Application Reference: 2025/0147

Site Address: 6 Tingle Bridge Crescent, Hemingfield, Barnsley, S73 0NR

Introduction: This application seeks full planning permission for a 'Single storey side and front extension to dwelling, to extend existing entrance and garage

Drawing Title
**PROPOSED FLOOR LAYOUT
AND EXTERNAL ELEVATIONS**

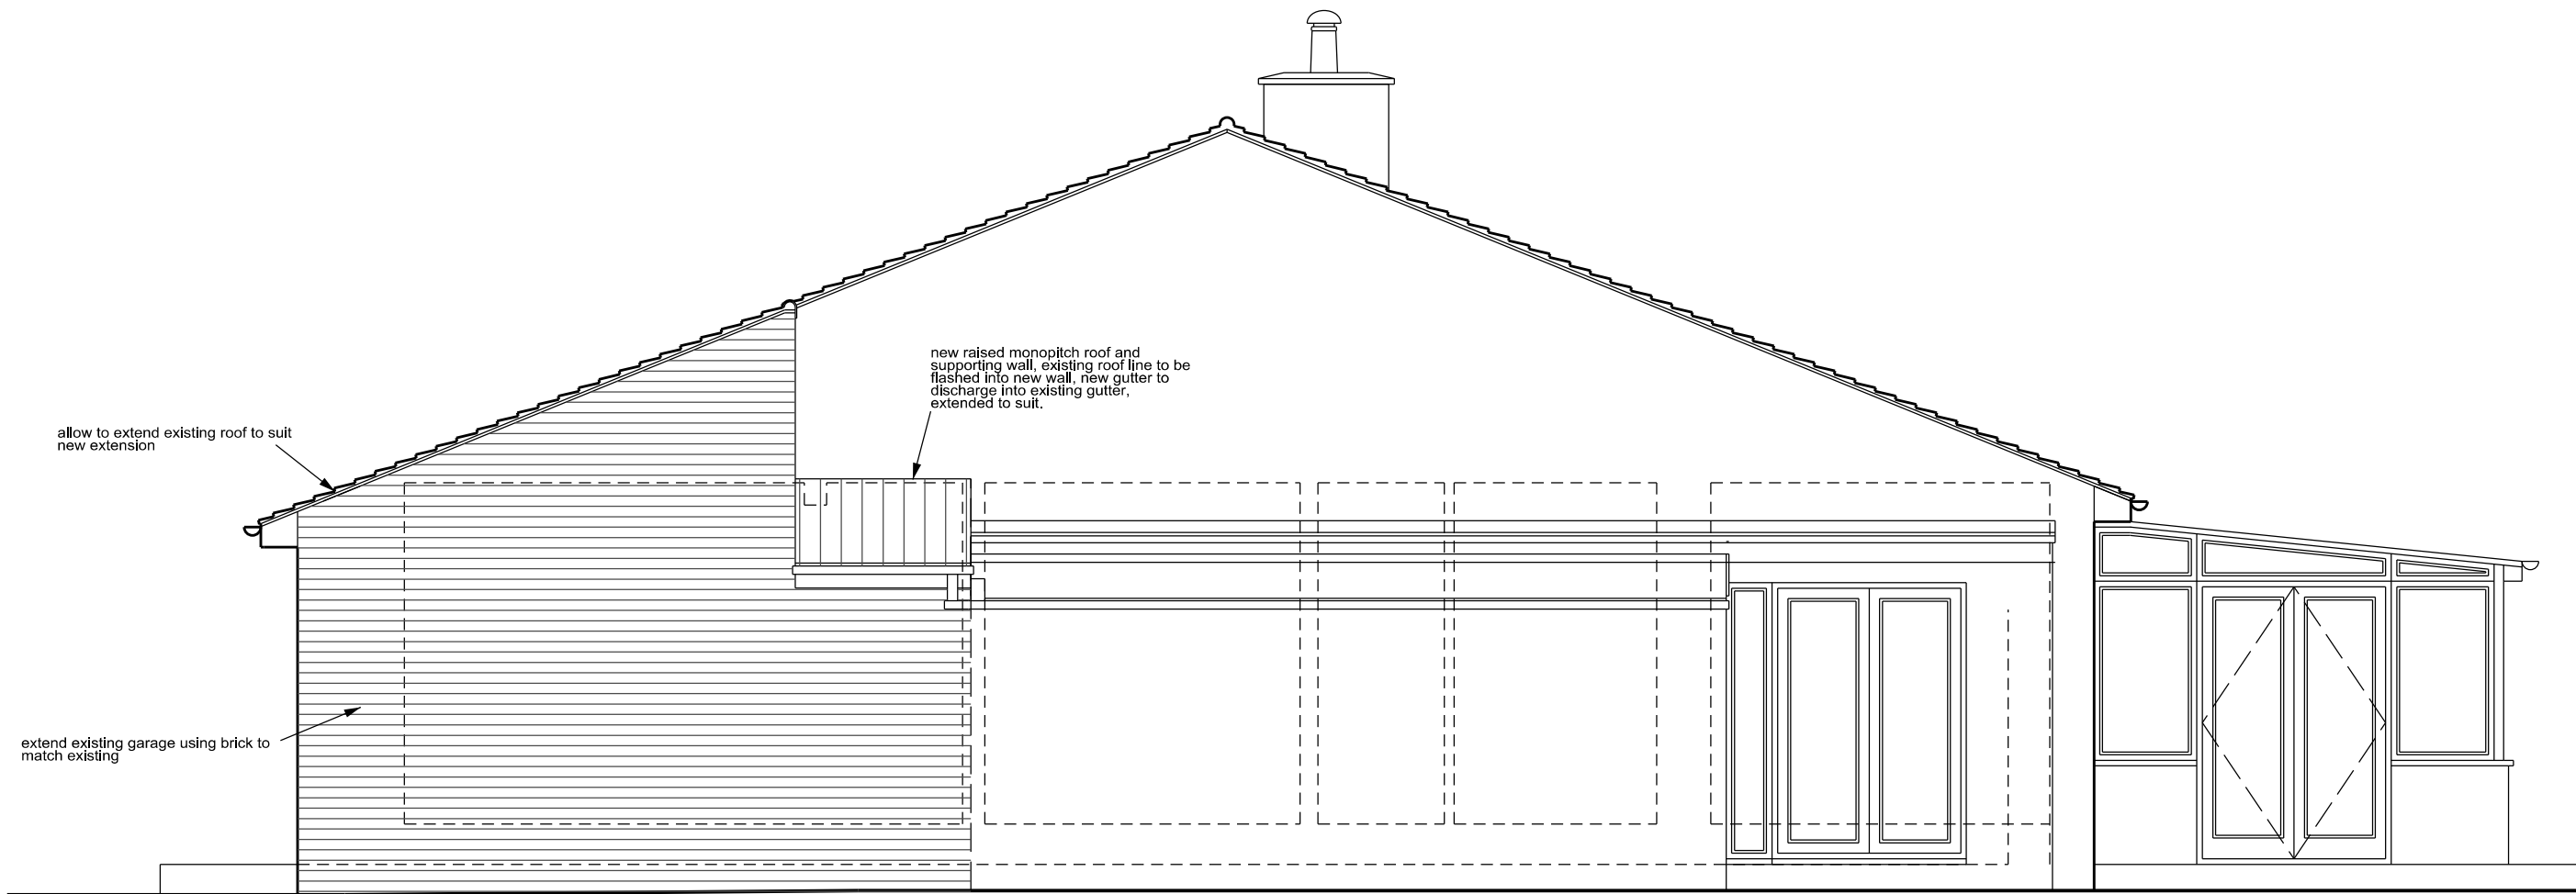
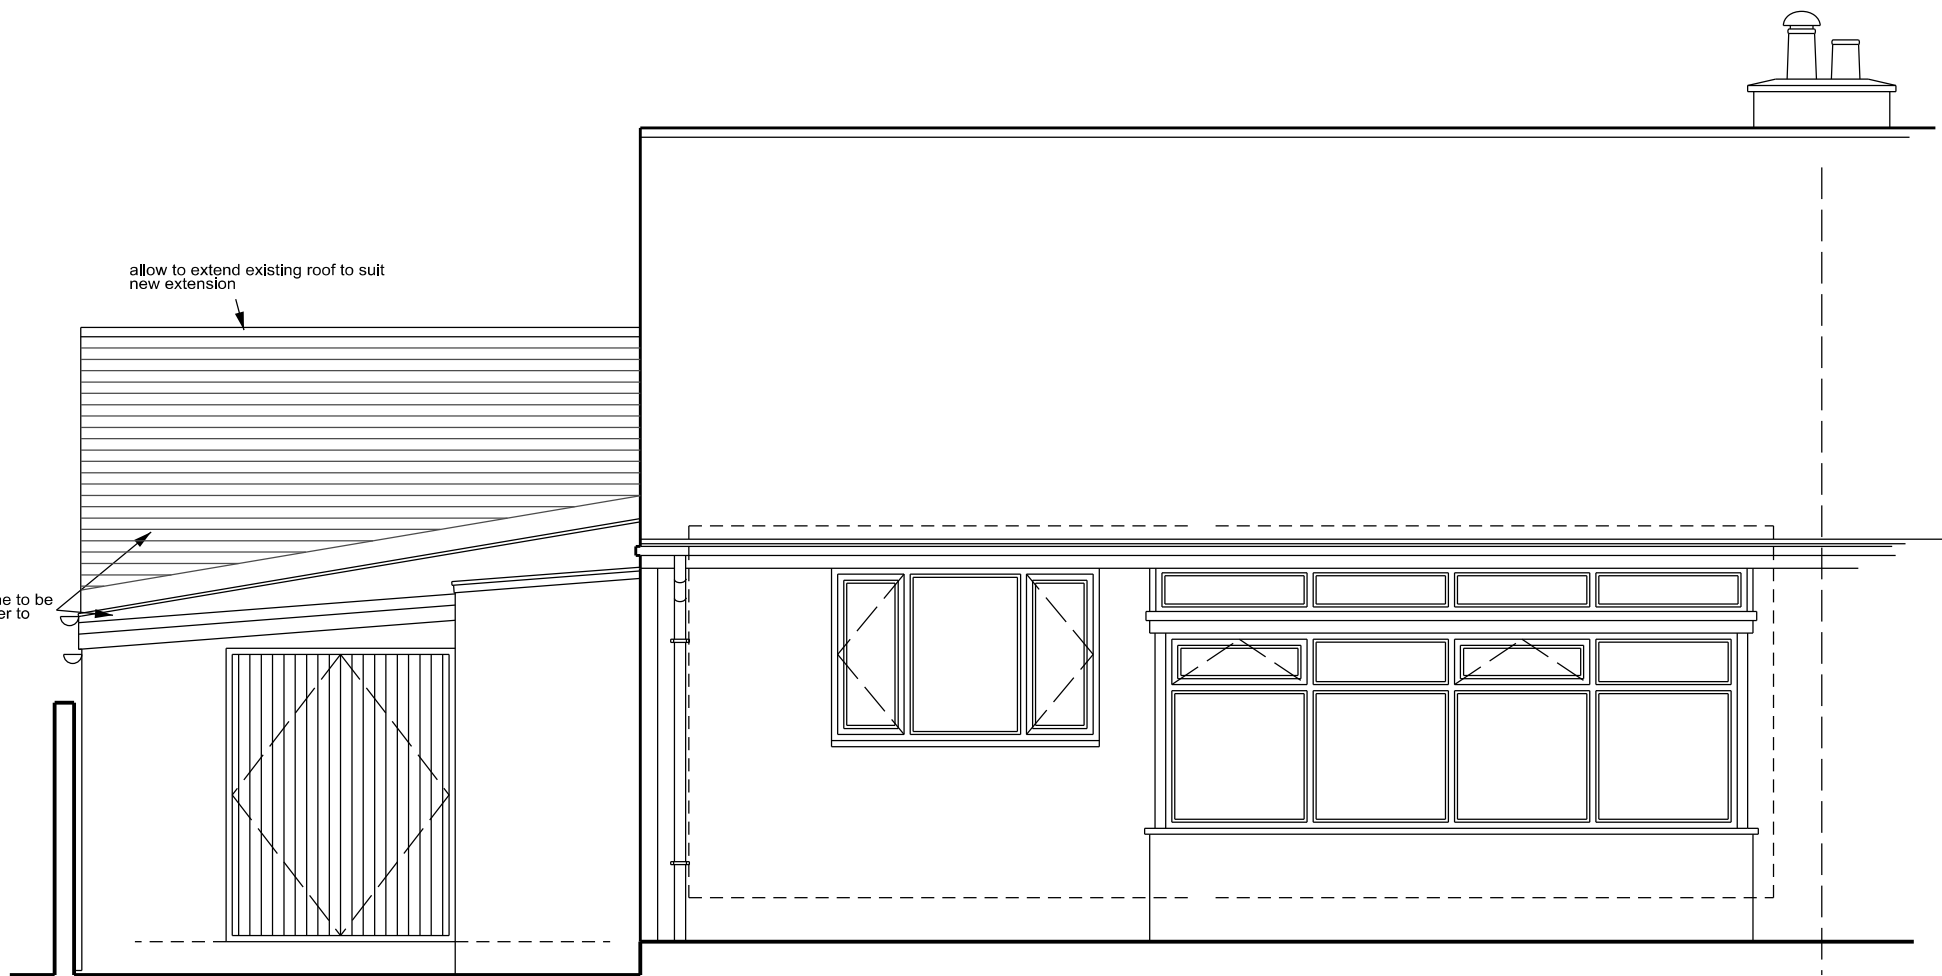
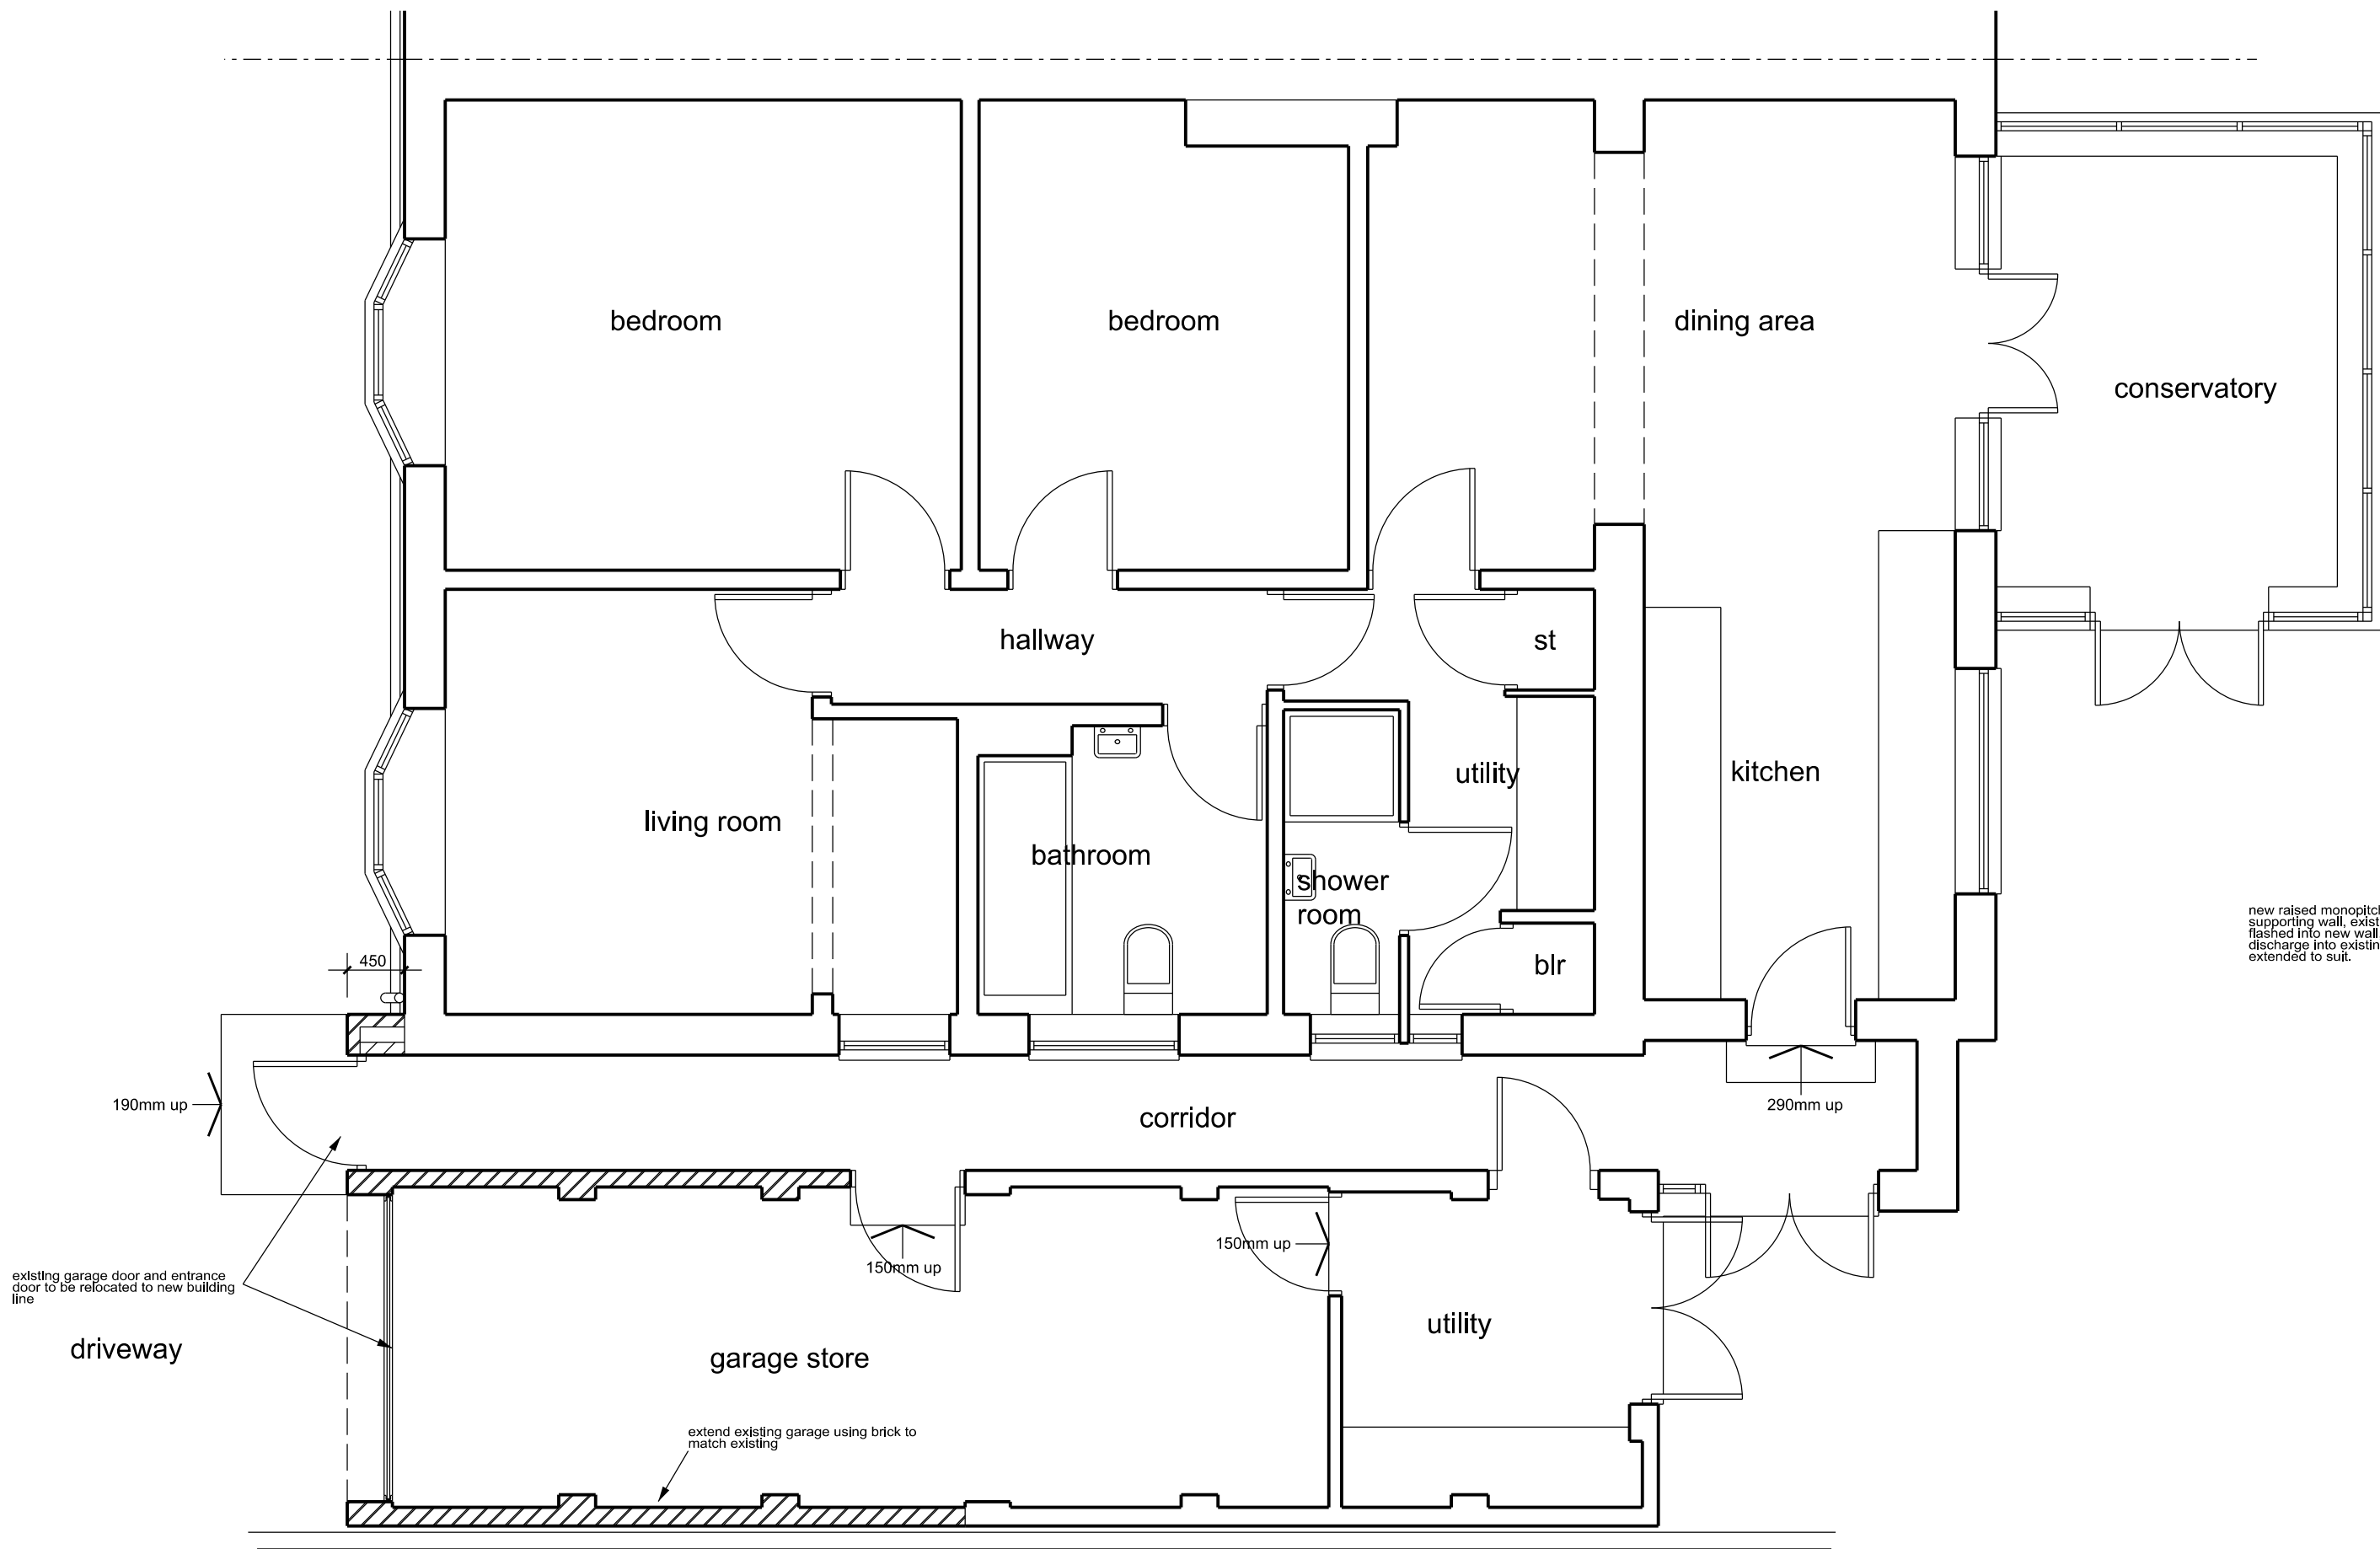
At approximately 18sqm, the extension is relatively proportionate to the existing dwelling which features a floor area of approx. 134 sqm. The side extension both proposed and existing, when the current walkway is included, are 3.7m wide, which is less than the two-thirds of the 7.8m width of the original house and is in accordance with the SPD. On corner plots extensions should be no wider than 50% of the width between the side elevation of the main dwelling and boundary treatment, which would not be achieved in this instance, however, the neighbours garden separates this plot from the adjacent highway, as such, this requirement would not apply on this occasion.

Whilst not strictly in accordance with guidance, the small 0.45m protrusion beyond the front elevation would cause no significant harm, especially when it only extends 0.17m beyond the projection of the original bow windows. Furthermore, the setback guidance is generally reserved for 2 storey extensions rather than single storey extensions. The proposal also has a lower roof than the original dwelling so remains a subordinate addition. Therefore, whilst not strictly in accordance with Guidelines, with limited harm to the character of the dwelling, the scale and design of the proposed extension would only be considered to have a limited impact on the character of the dwelling, in accordance with Local Policy D1.

In specific relation to the design of the proposed extension, it broadly replicates the existing garage and walkway extension but brought forward. With the main roof being extended over the new extension, this would help harmonise, at least on the prominent front elevation, the original dwelling and new extension, whilst the step down in roof height complies with the requirement for subordination to the original dwelling. With the existing front door and garage door proposed to be reused in the new extension, this demonstrates sustainability and familiarity, minimizing the impact of entirely new materials, which take time to 'weather' and look comparable to the features of the original dwelling. Overall, the design of the proposal should sit well within the street scene and have a limited impact on the character of the dwelling or broader street scene.

With the proposed extension being located as far as possible away from the attached neighbouring dwelling, there would be little or no harm to their amenity. Similarly, with the proposed extension being created in front of the existing garage and walkway extension, the proposal would have a limited impact on the amenity of the unattached neighbouring dwelling, which is situated towards the rear elevation of the application dwelling.
